**OXFORDSHIRE COUNTY COUNCIL'S RESPONSE TO CONSULTATION ON THE
FOLLOWING DEVELOPMENT PROPOSAL**

Application no: 13/01056/OUT

Proposal: OUTLINE - Up to 200 residential units, access, amenity space and associated works

Location: South Lodge Fringford Road Caversfield Bicester OX27 8TH

**Existing Junction Arrangement**

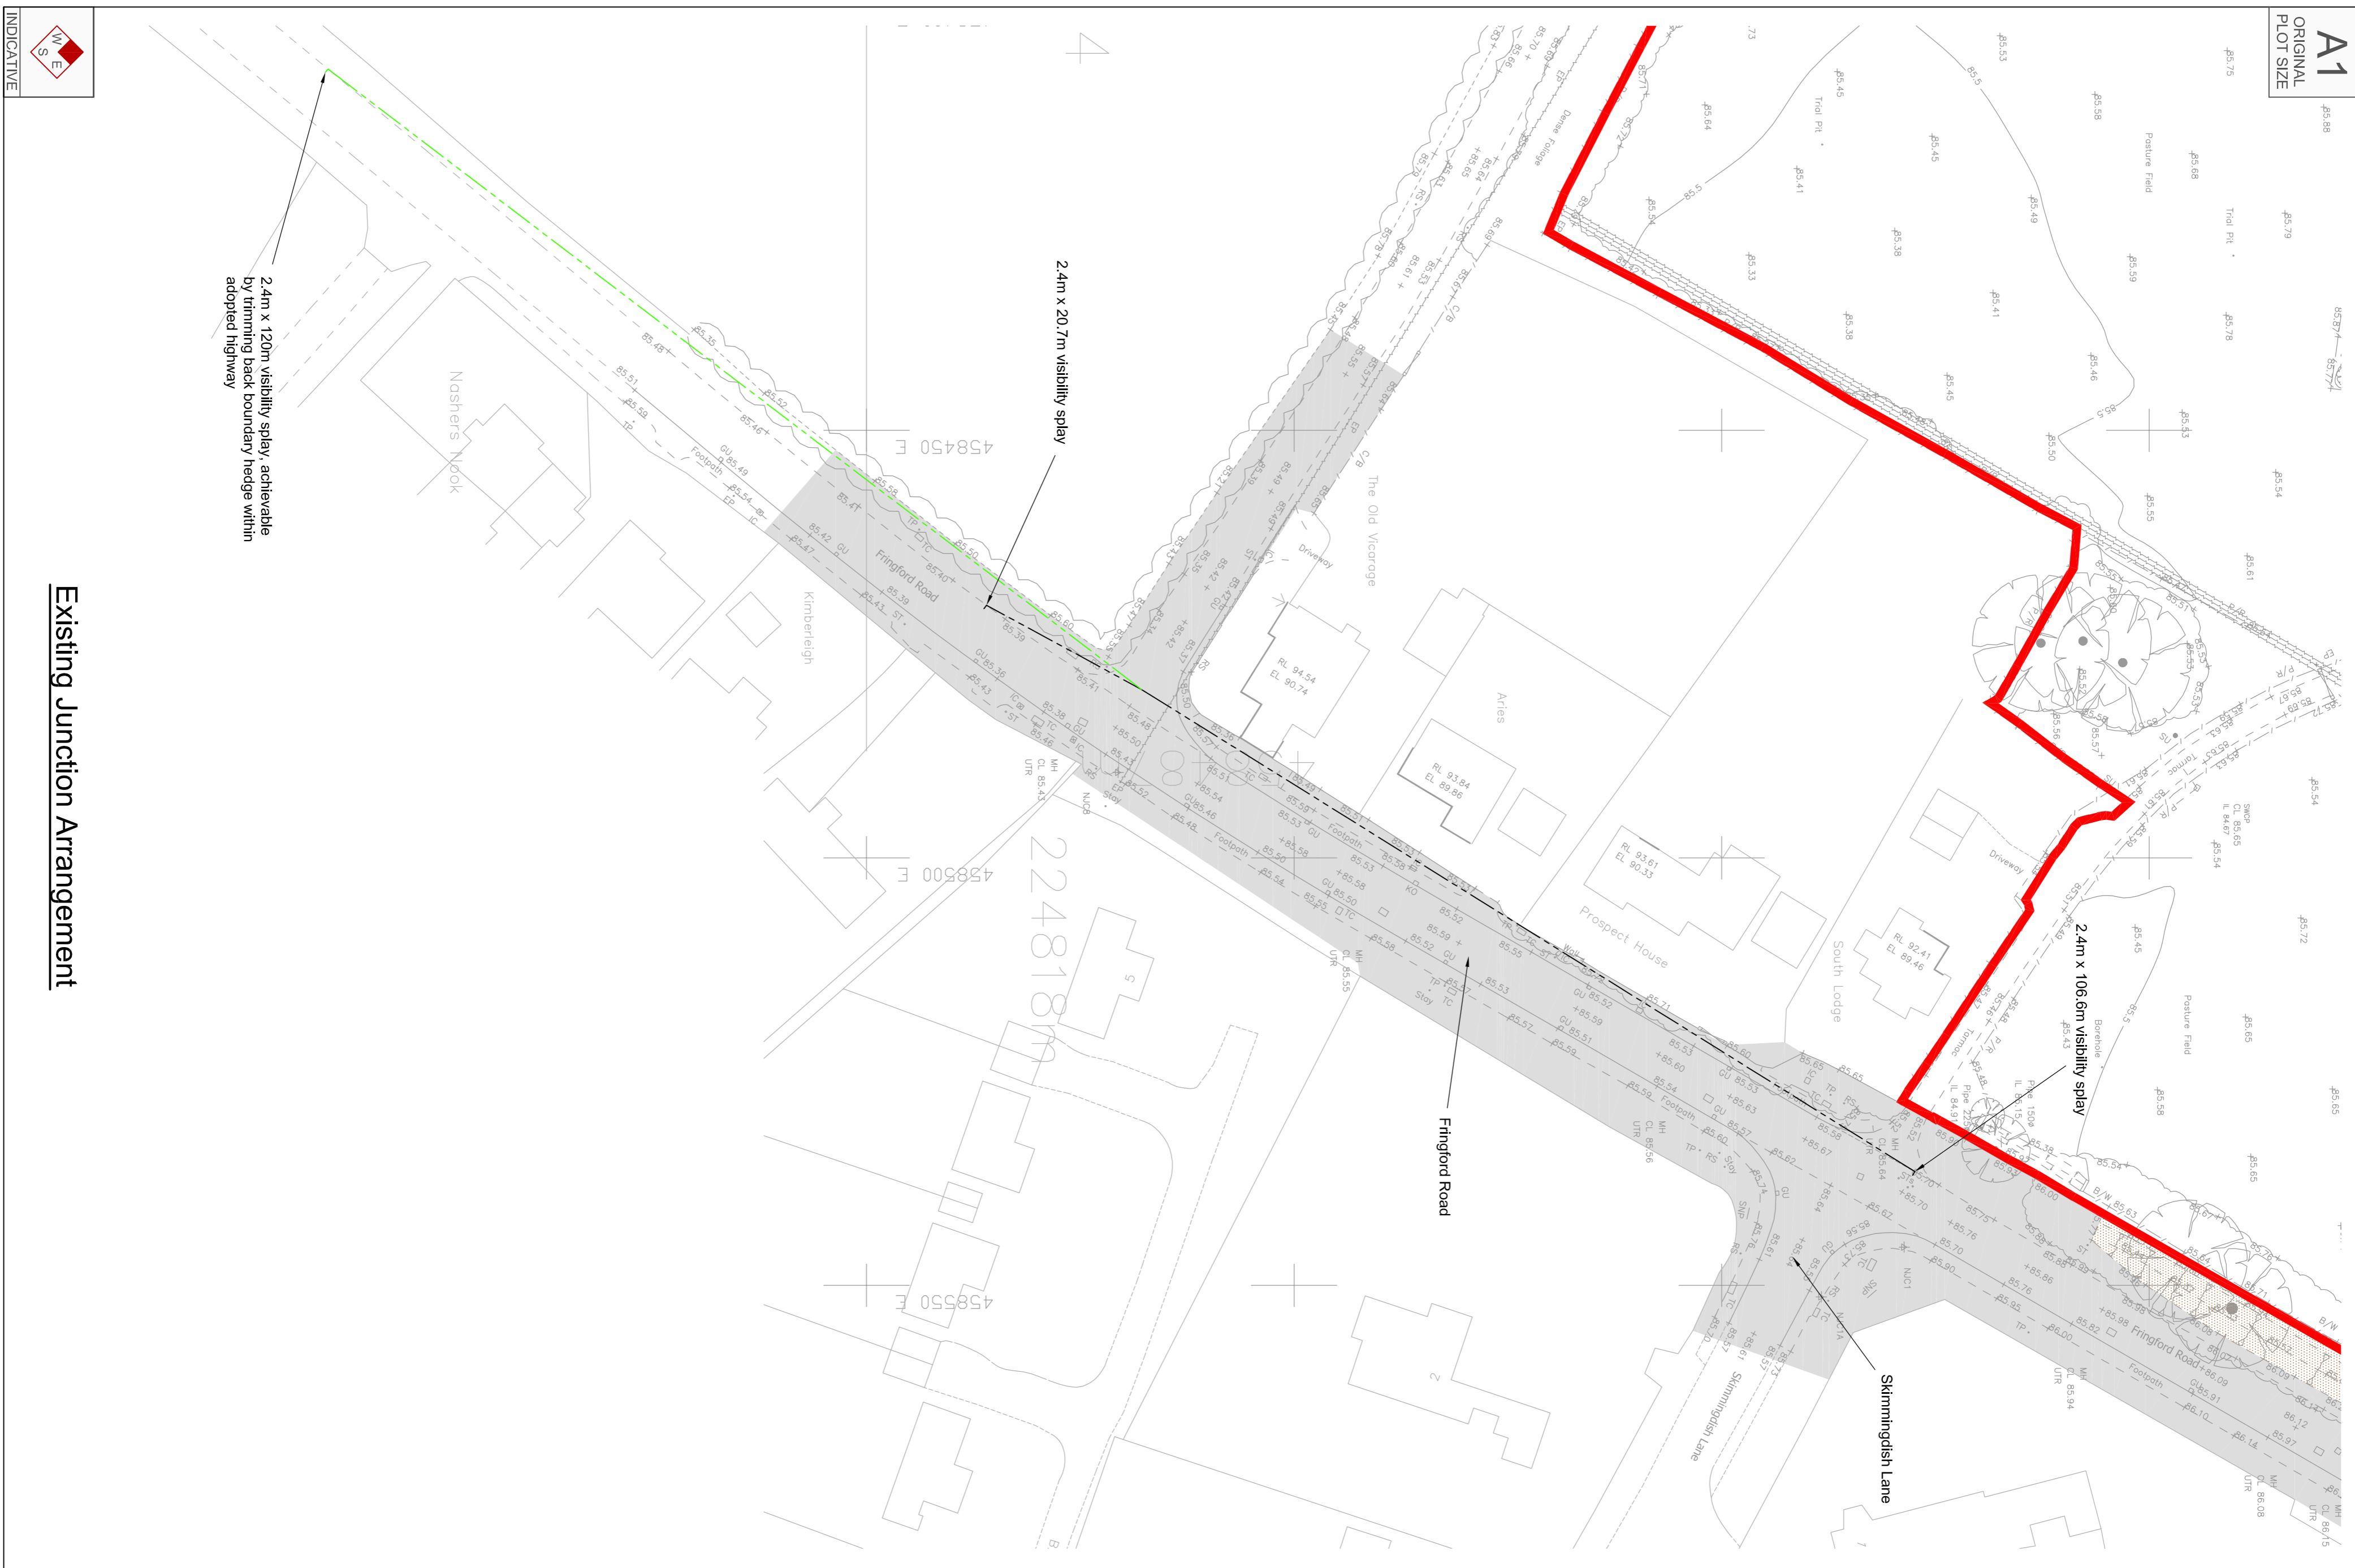
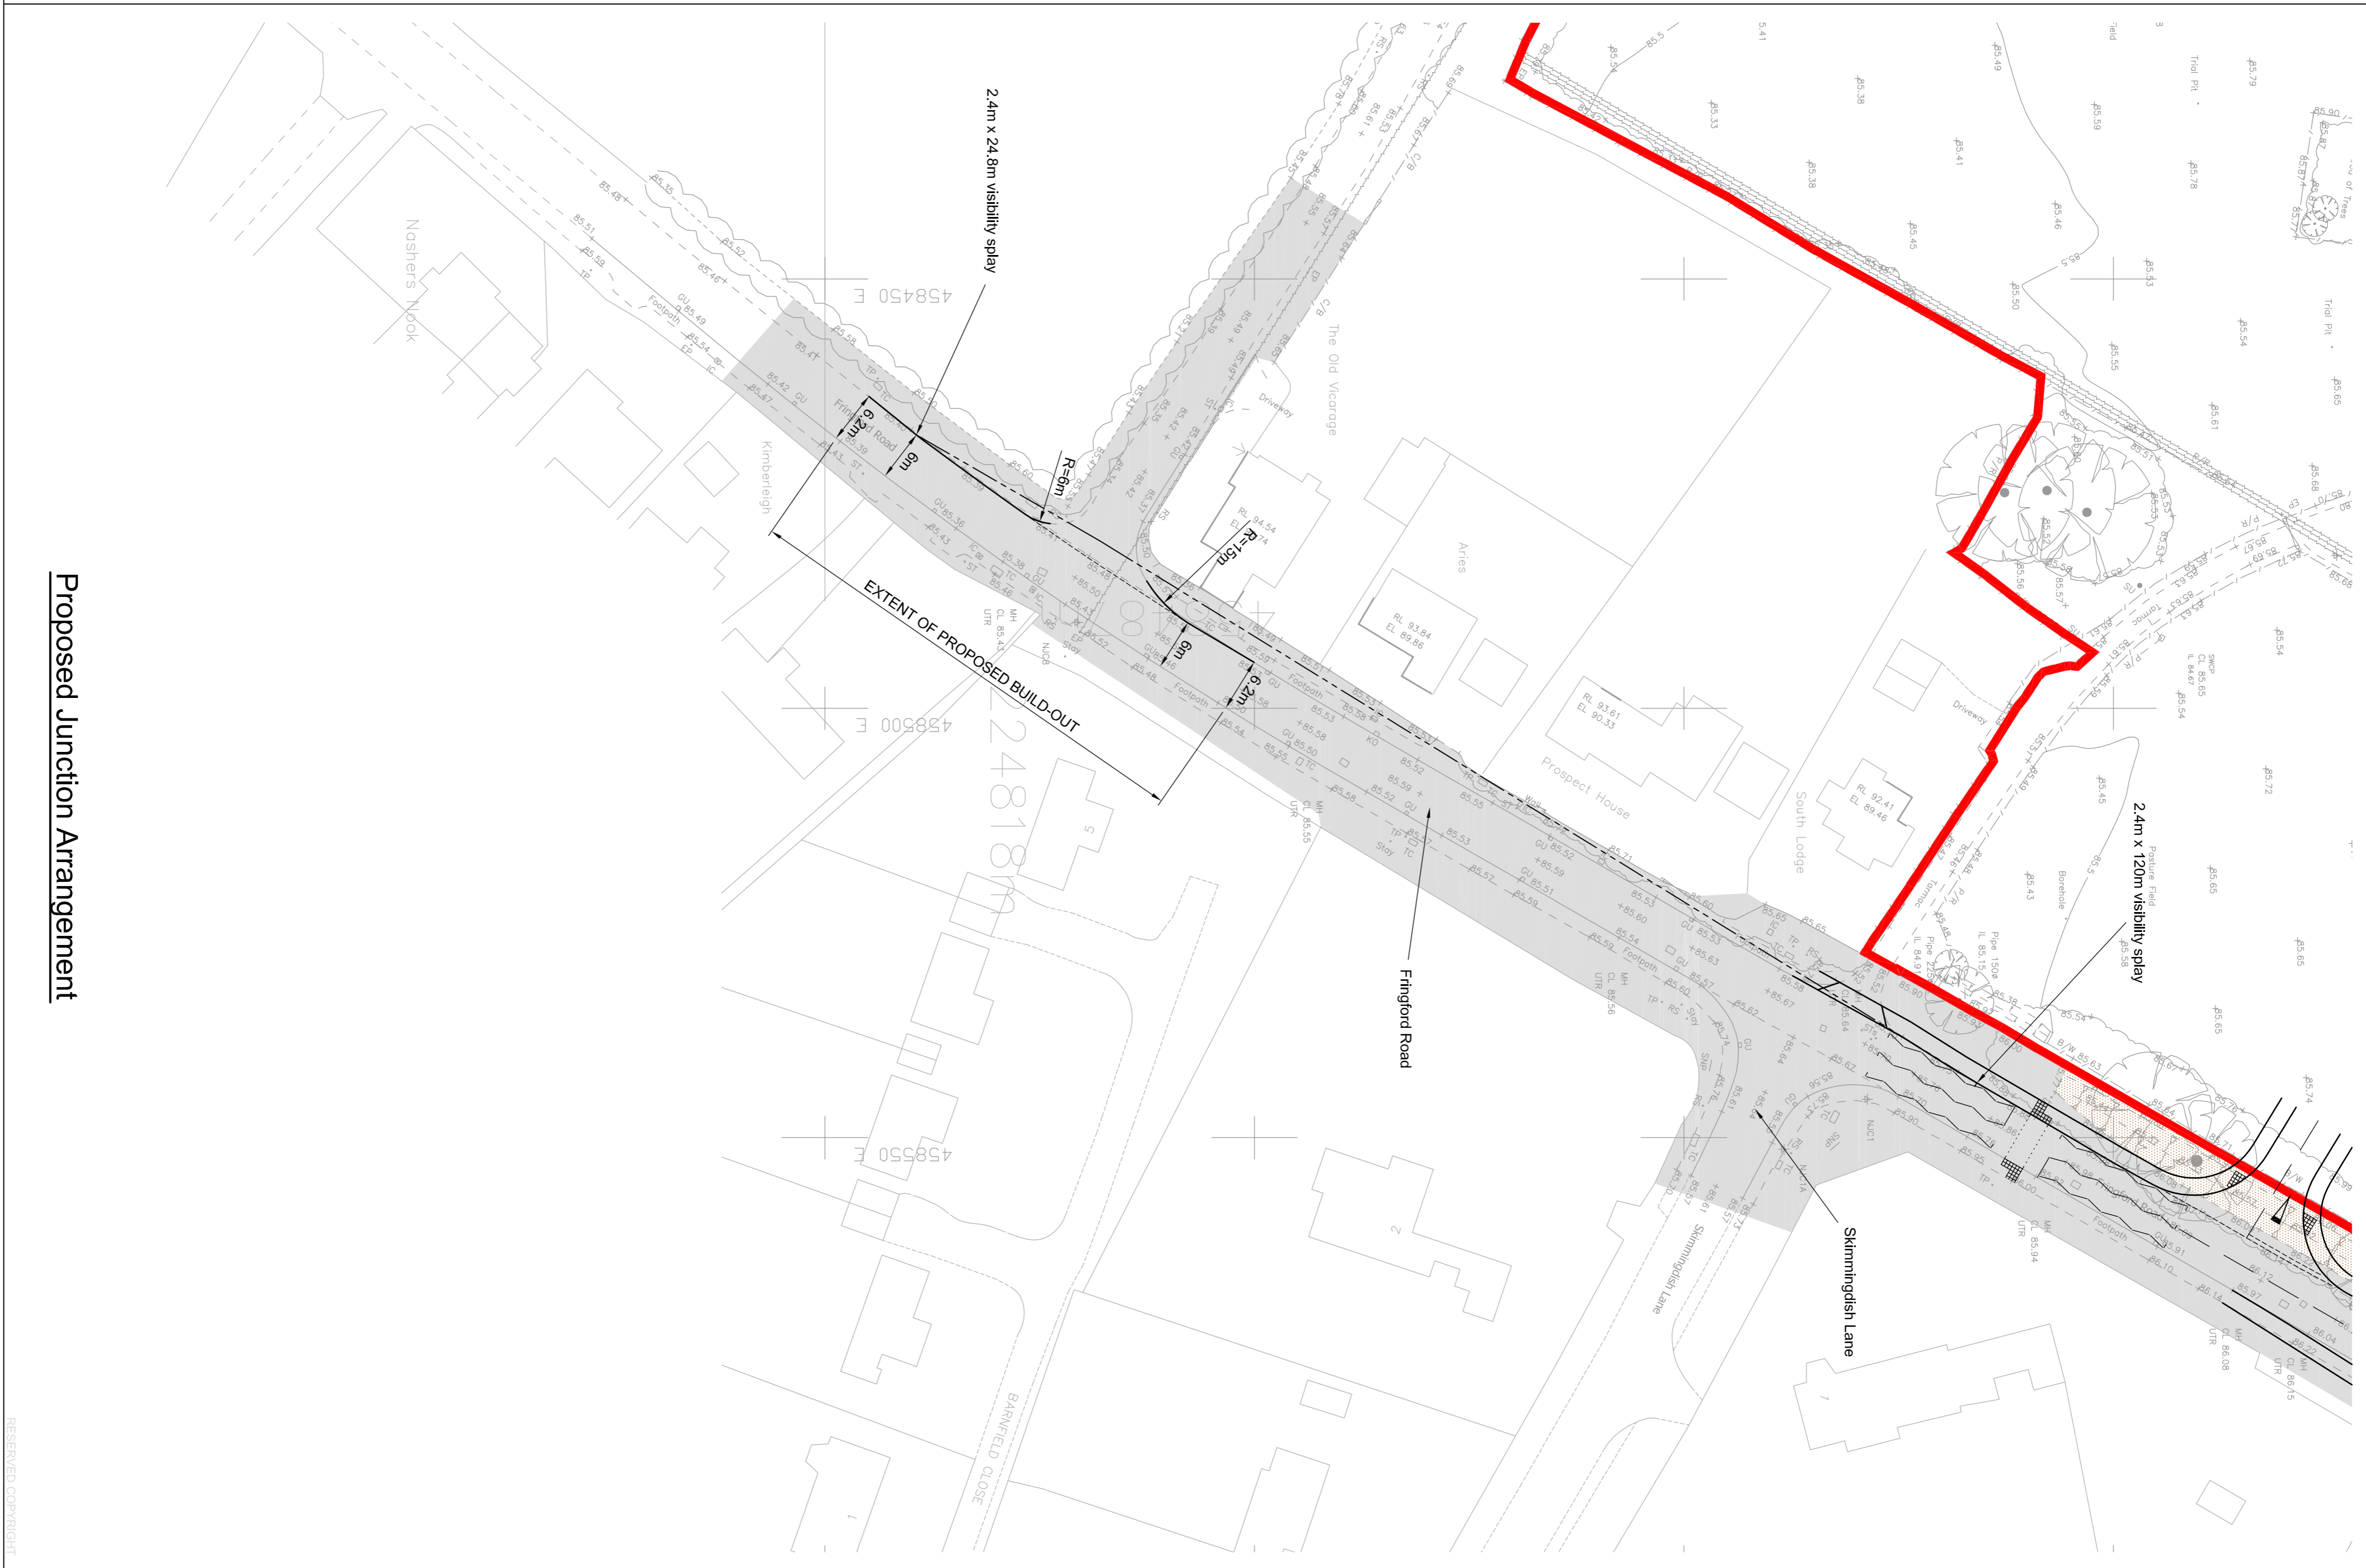
- **Highway safety concerns**, including:
 1. An adequate, safe highway access for the site has not been demonstrated. It is unclear whether the required access vision splay can be achieved within land owned or controlled by the applicant.

The application proposes a new vehicular access onto Fringford Road. The detail of this proposed access, including visibility splays, has not been submitted for consideration and approval. Vision splays of 2.4m x 120m will be required, provided that the 85th percentile speed of traffic in the vicinity is 40mph in line with the local speed limit. Such a vision splay would extend past the applicant's red-line application boundary, and would likely necessitate the removal of third party trees and vegetation to the north of the site. It has not been demonstrated that a safe, adequate access to the public highway can be achieved. **(Concern – highway safety)**
